From: James Cross <James.Cross@arun.gov.uk>
Sent: Thursday, November 21, 2019 4:13:52 PM
To: Jack Dowling [REDACTED]
Subject: RE: BR/256/19/PL - 2 Cavendish Road, Bognor Regis, PO21 2JW

Conversion of existing store to 2 bed dwelling to the rear of 2 Cavendish Road, fronting Sutherland Close.

Proposed Ground Floor Plan

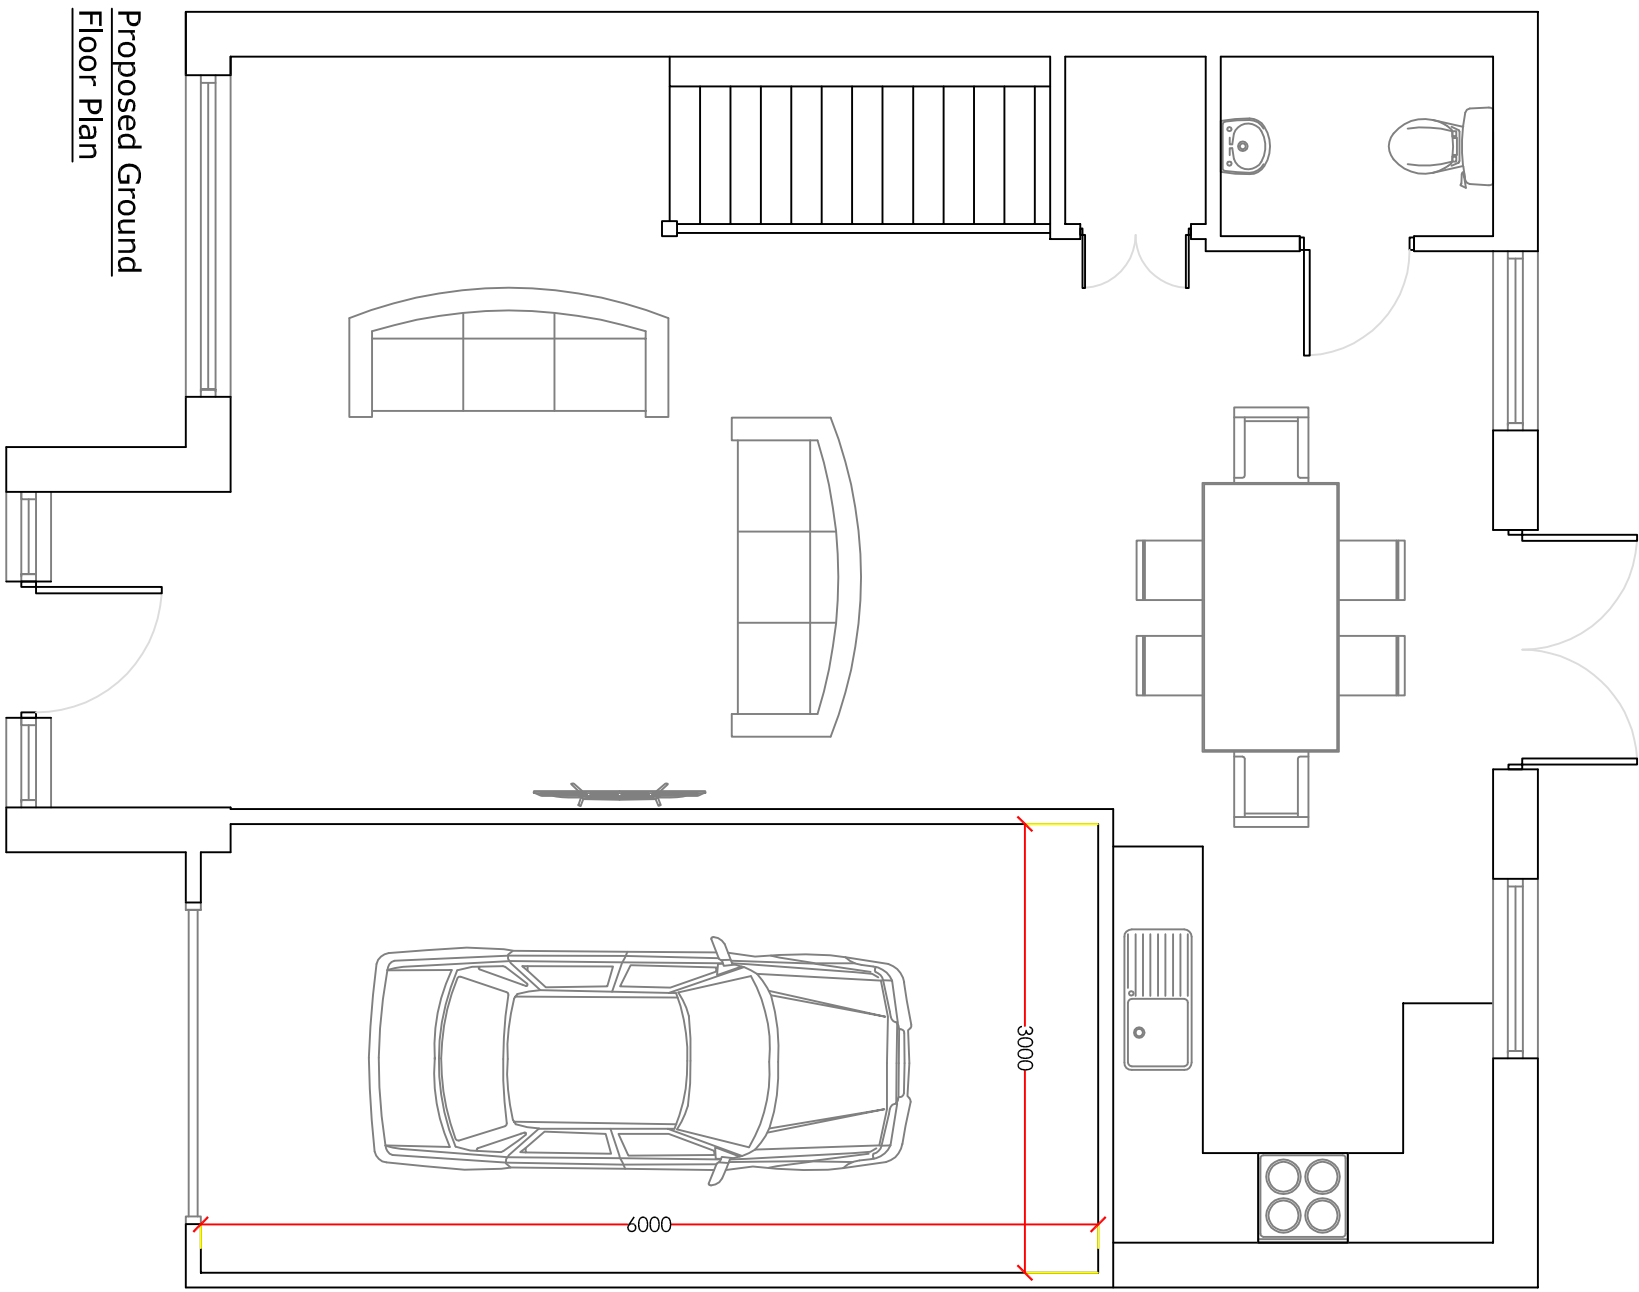
Many thanks for bearing with me over the weekend whilst I took the time to discuss the proposals with my management and Simon. In terms of the submitted 3 bedroom design, and owing to the previous planning histories on the site dating back to 2011, we would have concerns with the rear dormer window and it's proximity to the property to the south, combined with the potential for over massing impacts. Further, we would also have concern relating to privacy deriving from overlooking to the rear garden spaces of properties to the south. Whilst I appreciate that this is somewhat disappointing news, it is with regret that we would be unable to support the application in its current form.

I noted from our previous email correspondence your desire to work with the Local Authority to achieve a development on this site. Having discussed possibilities with management, we would be happy for you to remove the rear dormer window and utilise velux style rooflights, positioned 1.7m above FFL. This would result in a reduction in bedrooms from 3 down to 2. This would provide a development of kinds on the site, which would overcome the concerns raised.

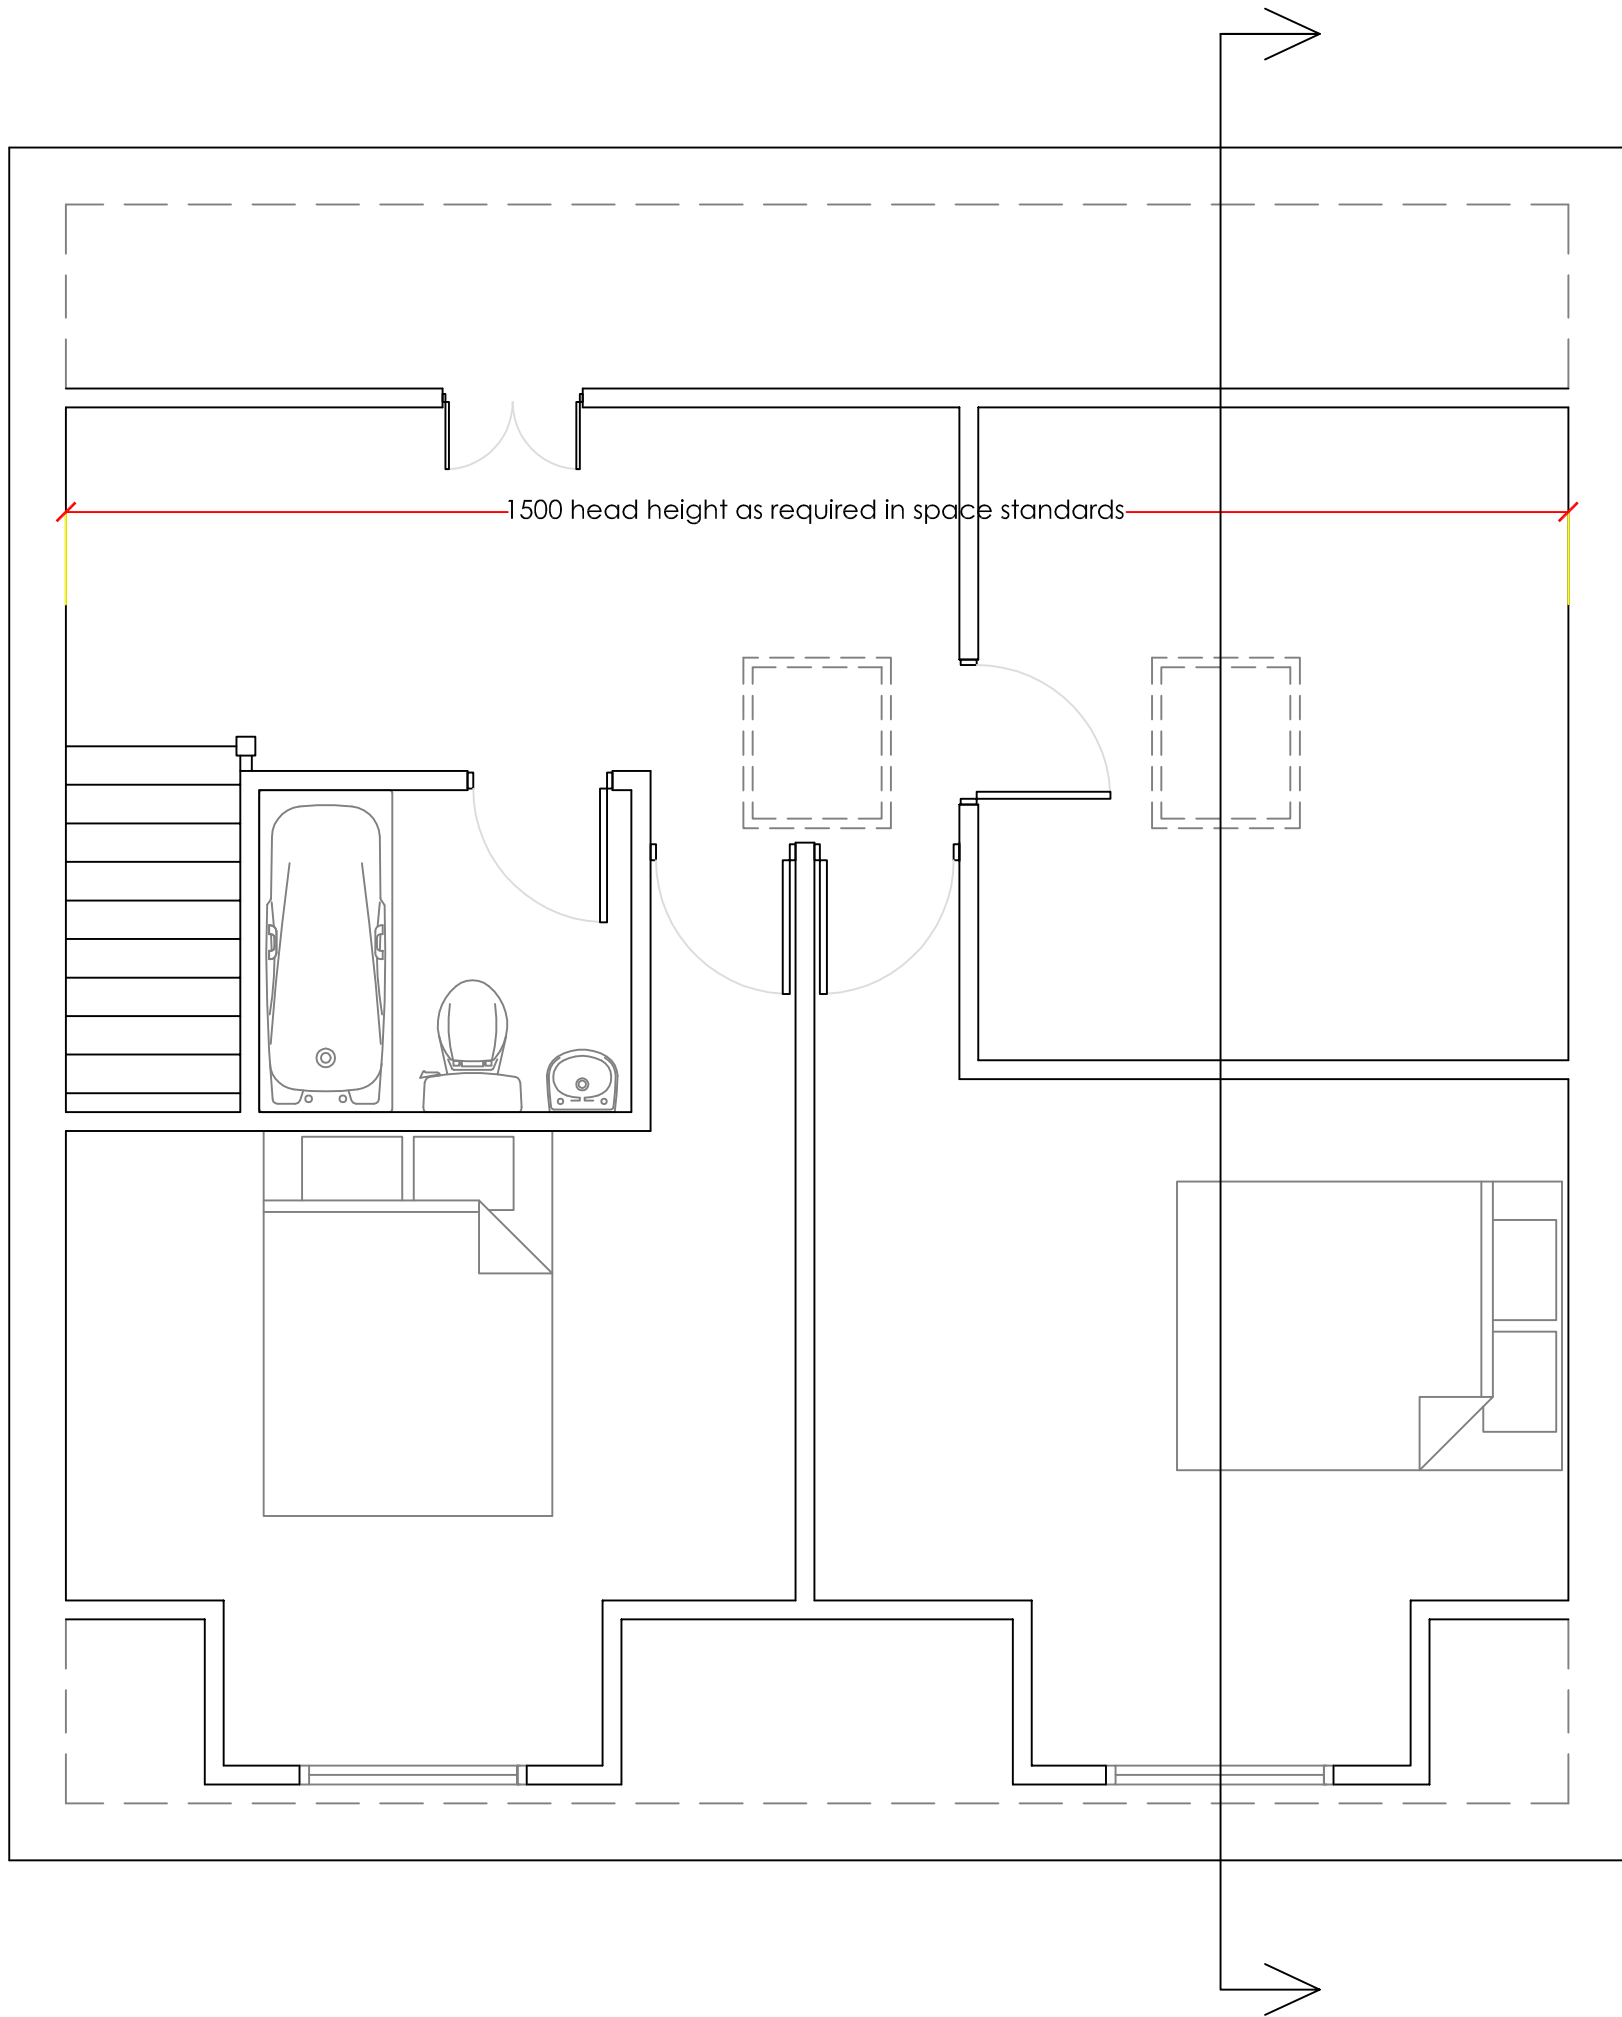
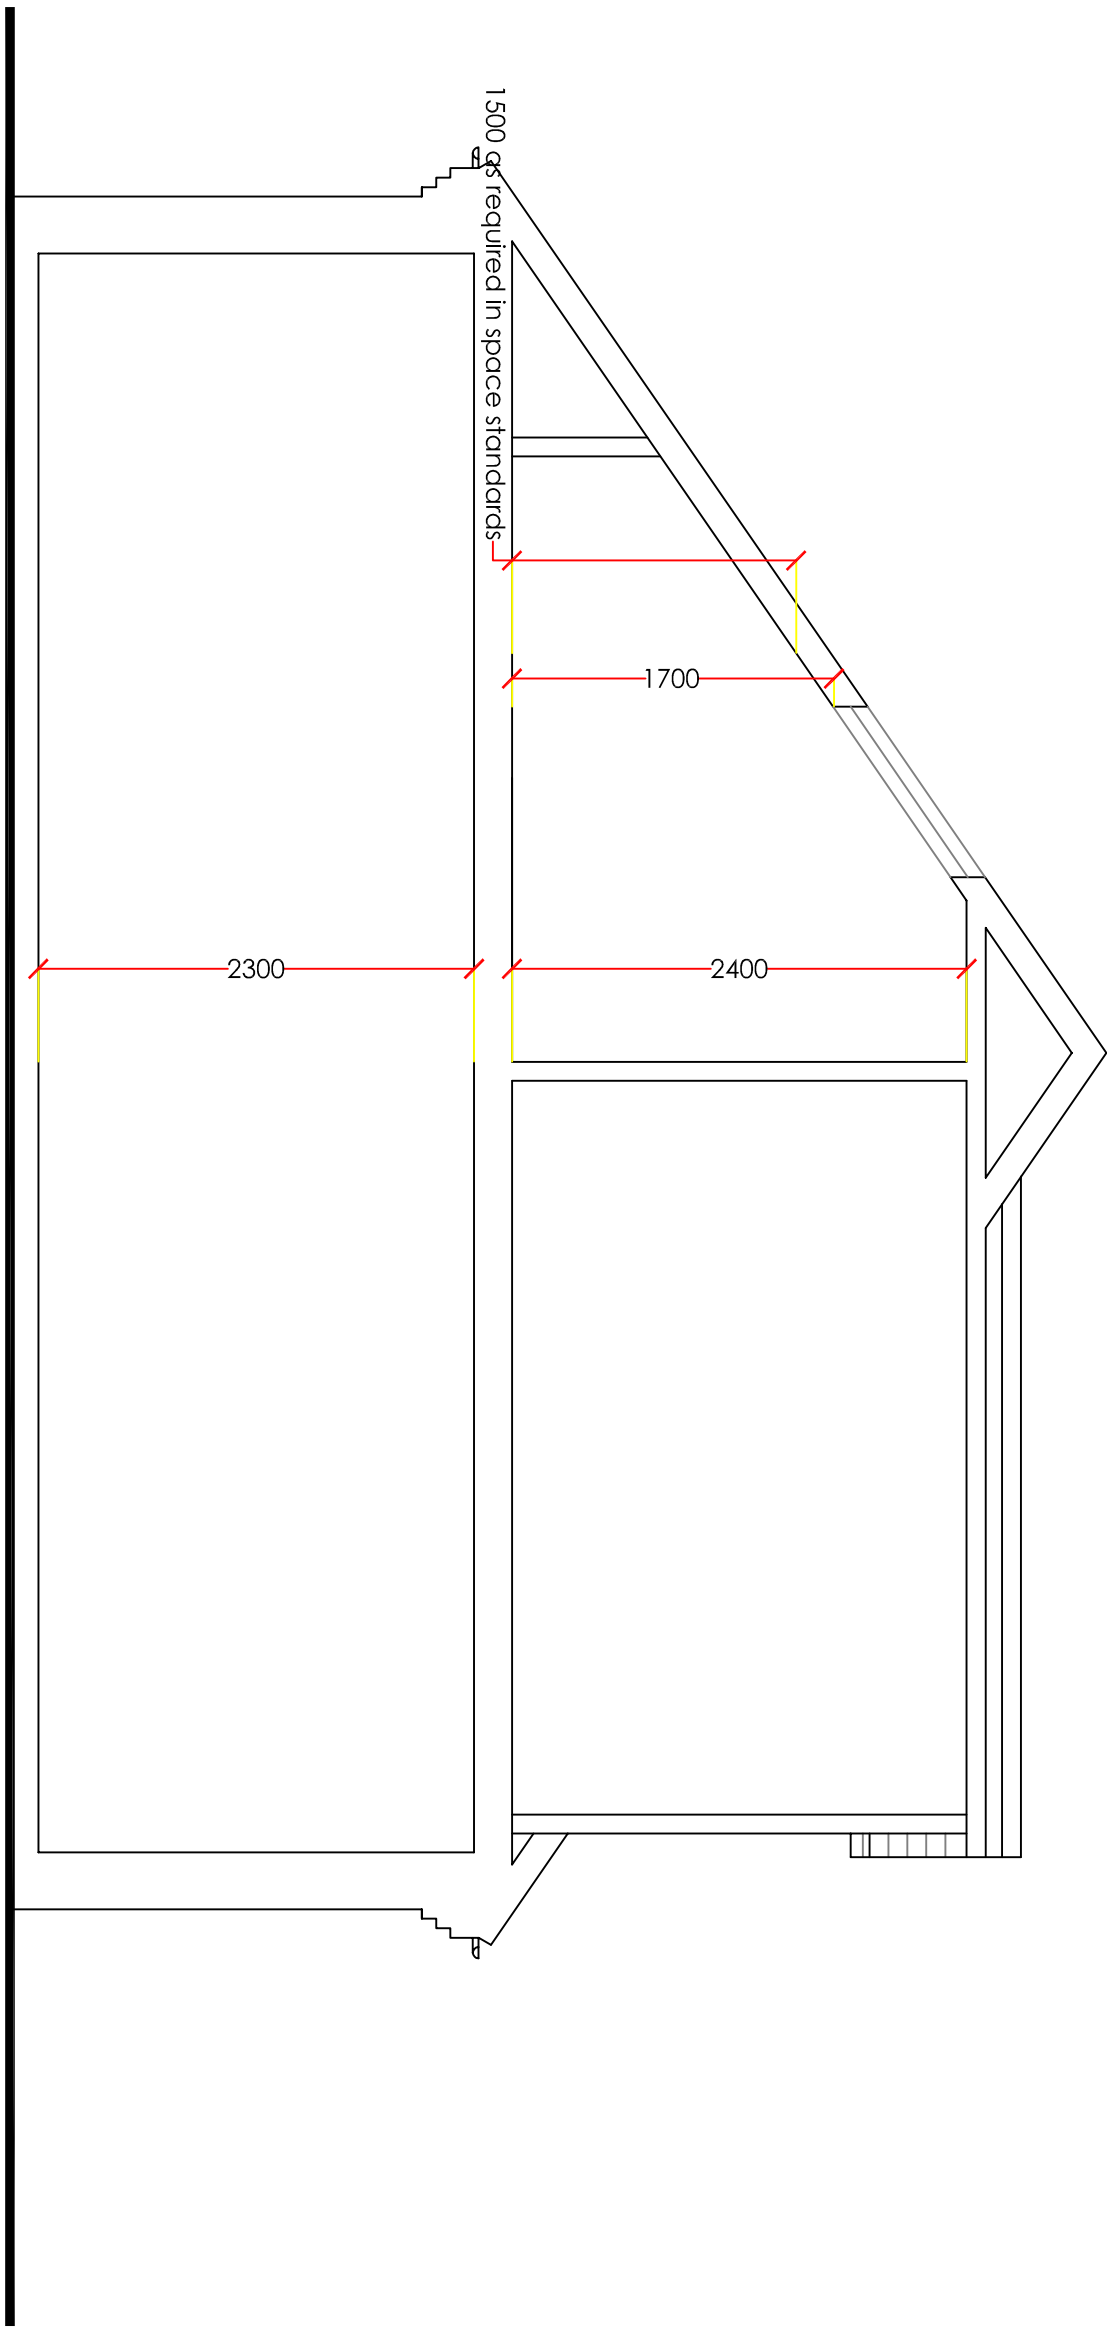
1. Could you provide an internal section to show how the pitch of the roof impacts upon internal spaces in the rooms to the rear? I envisage significant concern will be raised given that what is in effect a bedroom is shown to the rear. I will obviously need to assess this as such against internal space standards etc. I also need to be satisfied, through the submission of a section, to ensure the velux rooflights are 1.7m above FFL to overcome issues of overlooking etc...

Proposed First Floor Plan

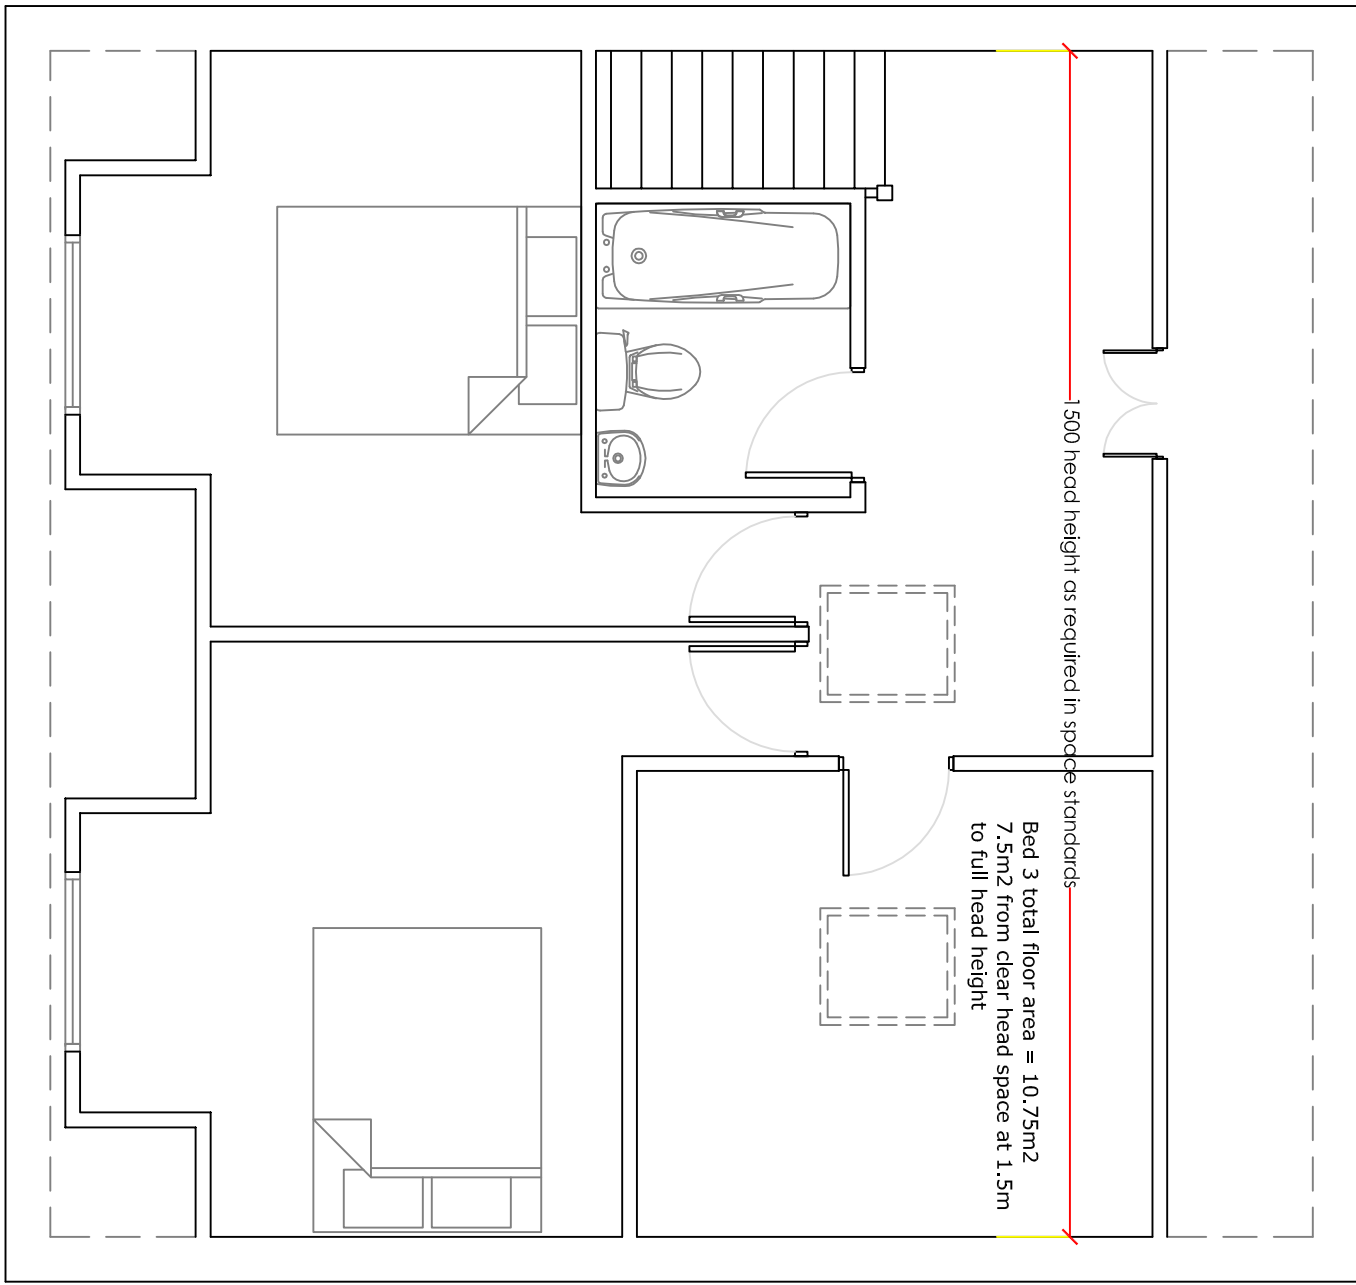
2. Could you please provide a line on the plans showing where the pitch of the roof cuts into the headspace? This will allow me to have a better understanding of how much internal space is usable.

3. Please label the third room accordingly – if this is intended on being a bedroom, please show it as such. If it is to be a study or a snug etc... then please label/furnish accordingly. This is to provide all parties with sufficient clarity in moving forward. I envisage if this were to be a bedroom then it would not likely meet with internal space standards.

Please find attached as discussed, please see notes on plans showing that bed 3 falls within space standards. We are happy to extend the determination deadline. Please do not hesitate to contact me if you require any further info.
